HINCKLEY NATIONAL RAIL FREIGHT INTERCHANGE

Project reference TR050007

Post hearing submission ISH1 and CAH1 [Appendix C Applicant's Updated Responses to the ExA's Initial Observations on Drafting of dDCO]

Applicant's Updated Responses to the ExA's Initial Observations on Drafting of dDCO

Drawing file: TR050007 / TR050007-002095-2.32 Hinckley NRFI Outwood Level Crossing Footbridge - Illustrative Design.pdf

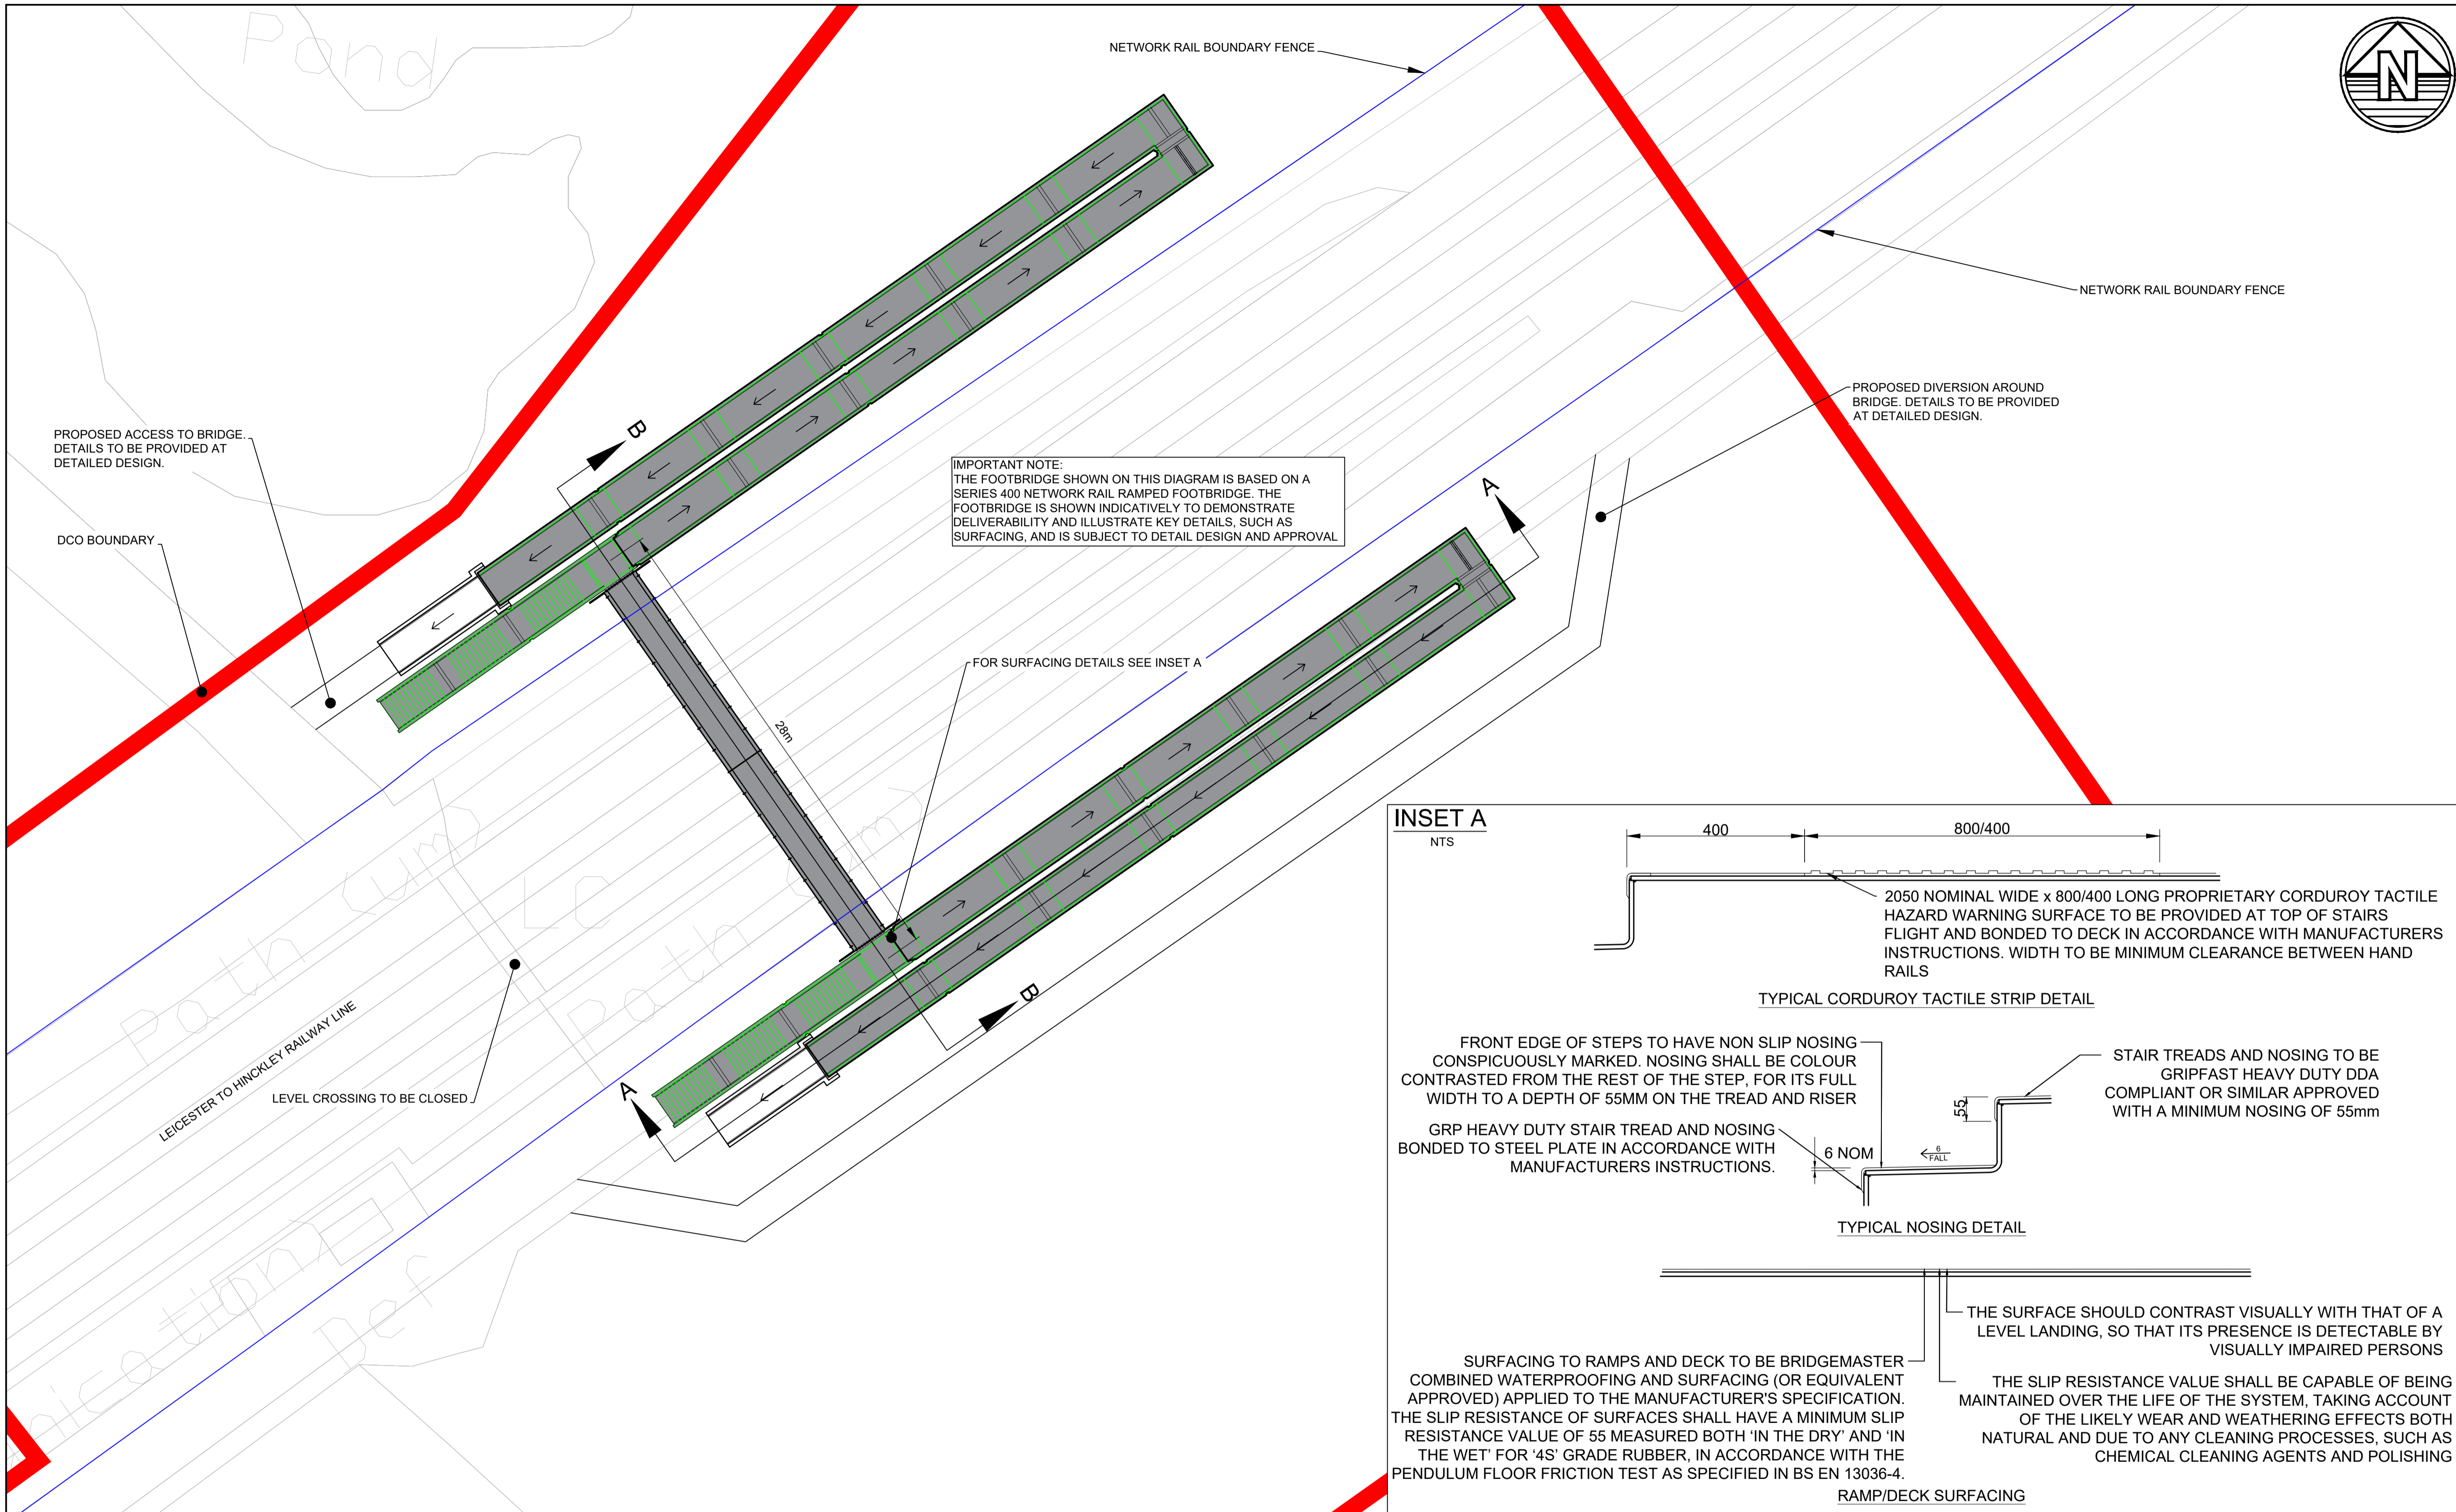
19.	Work 20	The ExA would like to confirm whether that the footbridge would be accessible to all, including those using wheelchairs and buggies, and is concerned as to whether the plans show sufficient land to indicate the maximum size to accommodate this usage. If such a provision for access for all is proposed how is this to be secured	The proposal is to close an existing level crossing and to provide a footbridge as a replacement. The current level crossing provision is from a public right of way through a field which is not easily accessible to those using wheelchairs and buggies. It is understood that the current level crossing is understood to have stepped access to the railway. The highway authority has not raised any concern with regard to accessibility proposals, or as to whether or not it should be a ramped bridge . The design of the proposed overbridge is currently under discussion with Network Rail and several potential options for the

Matter	Provision	Issue or Question Raised	Applicant's Response
			<p>structure are being considered. The Applicant has ensured that there is sufficient land available on both sides of the railway to provide a ramped bridge if this were to be required.</p> <p>The Applicant confirmed it would continue to liaise with the highway authority in respect of the bridge crossing.</p>
